From: Hill, Grace <Grace.Hill@e-lindsey.gov.uk>
Sent: 02 June 2026 15:40
To: Sutton, Catherine
Cc: _planningadvice
Subject: H07-0477-26 ecology comments

H07-0477-26 - Hillgate Farm Station Road Gedney Hill Spalding PE12 0NP

Change of use of agricultural to land for holiday lets, including the siting of 4 No Shepard's Huts & 1 No Lodge (part retrospective)

Post-Development Plan
Post-Development Map

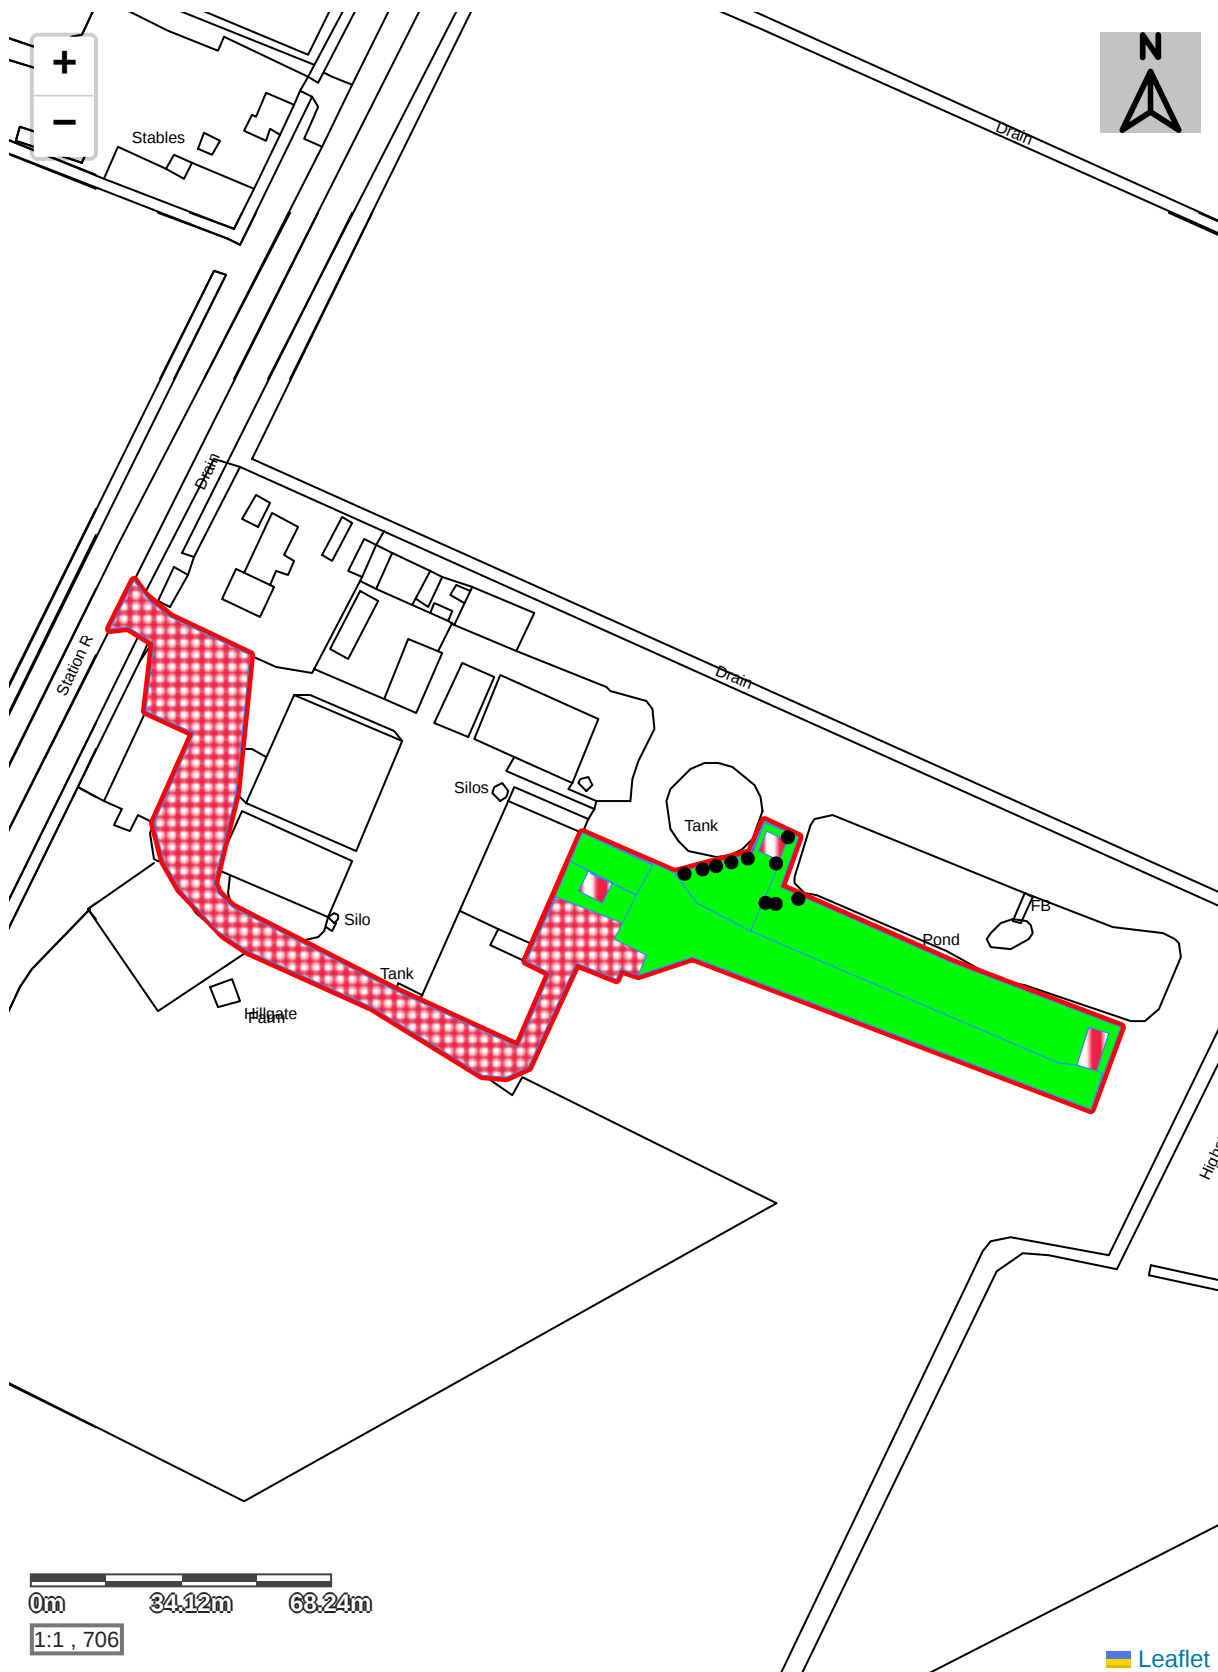
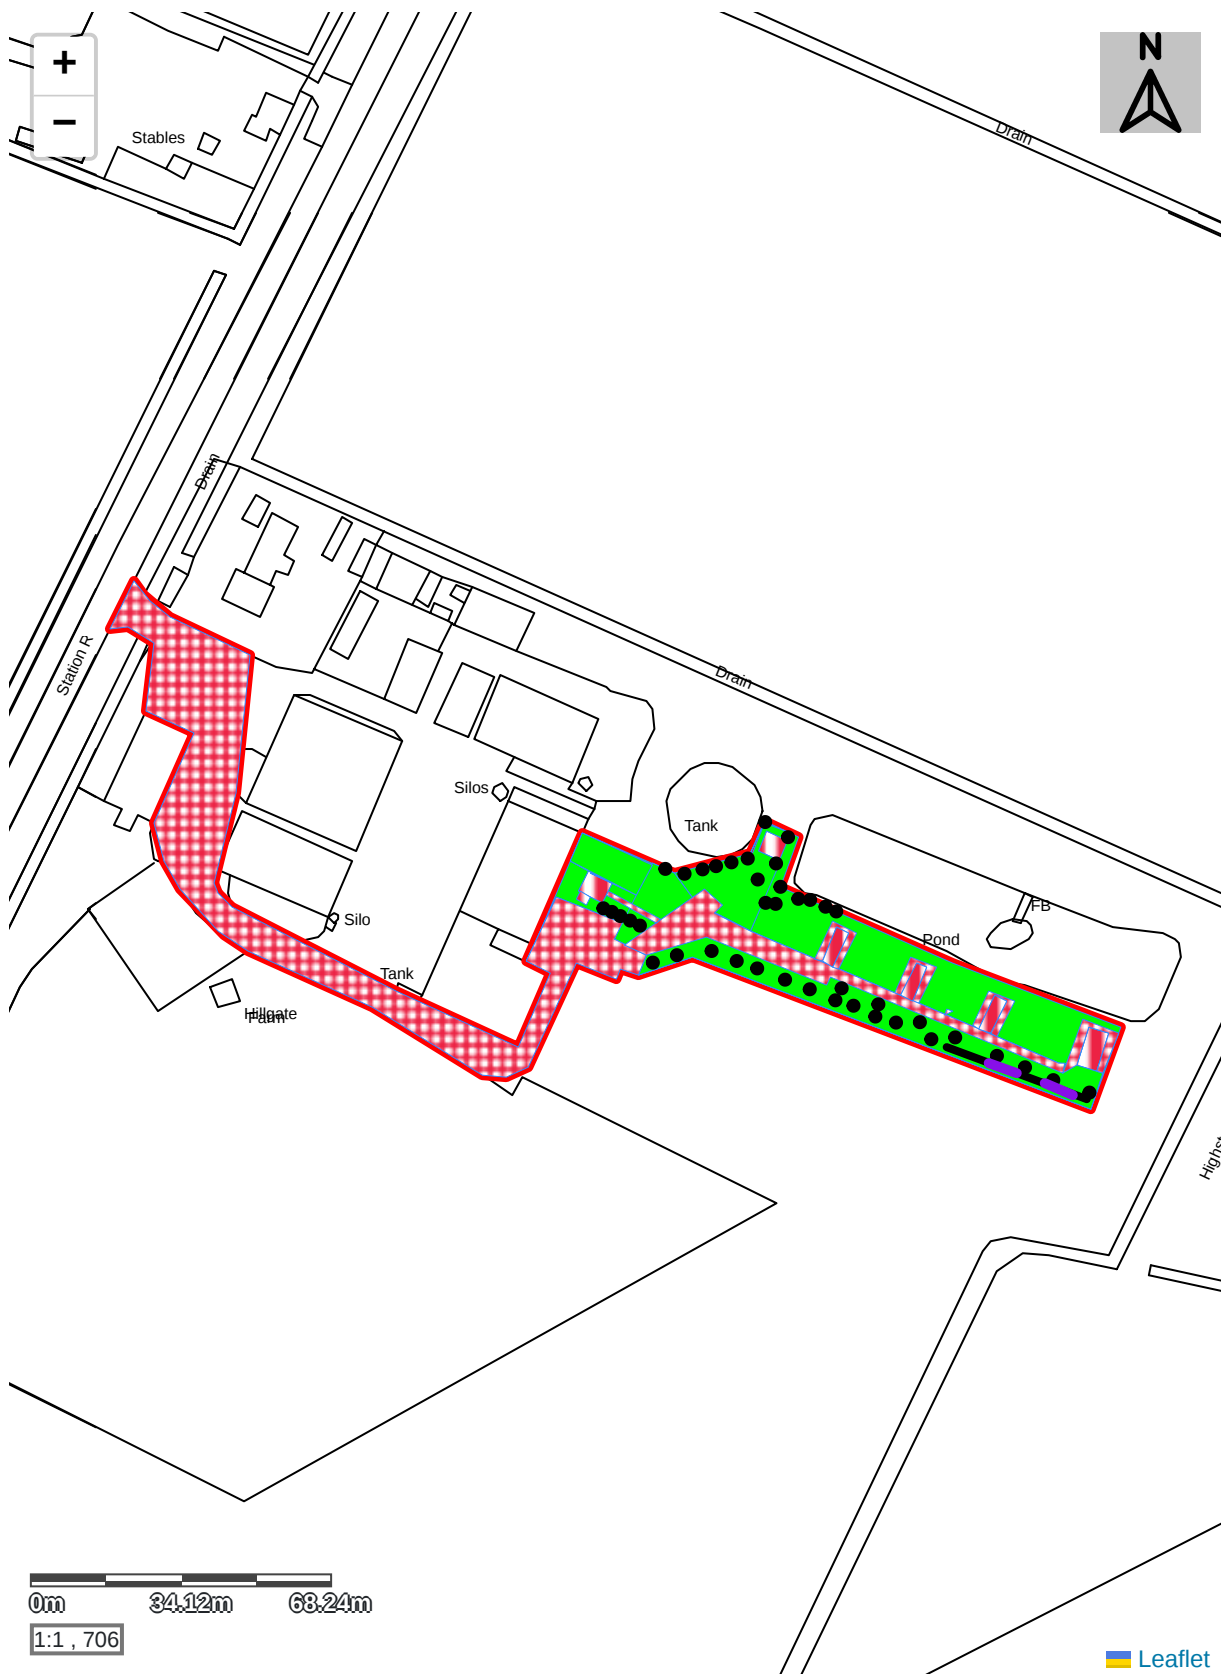
- We consider that in this situation, the creation of 'Modified Grassland in Good condition' would be at an increased risk of failure arising from external pressures such as higher footfall, increased activity from dogs and increased dog waste as well as increased vehicular use across the site. Because of this, we would recommend that the current modified grassland be retained as modified grassland in moderate condition would mean that there would be a net gain of 4.29% onsite, showing that 10% mandatory net gain would not be achieved.
- One way to achieve 10% net gain in this situation, could be by planting a total of 32 trees onsite to achieve moderate condition. This would be a further 7 trees to be planted on top of the current proposal of 25. We would request these extra trees be planted in proximity to other baseline trees/scrub to encourage habitat connectivity post-development.
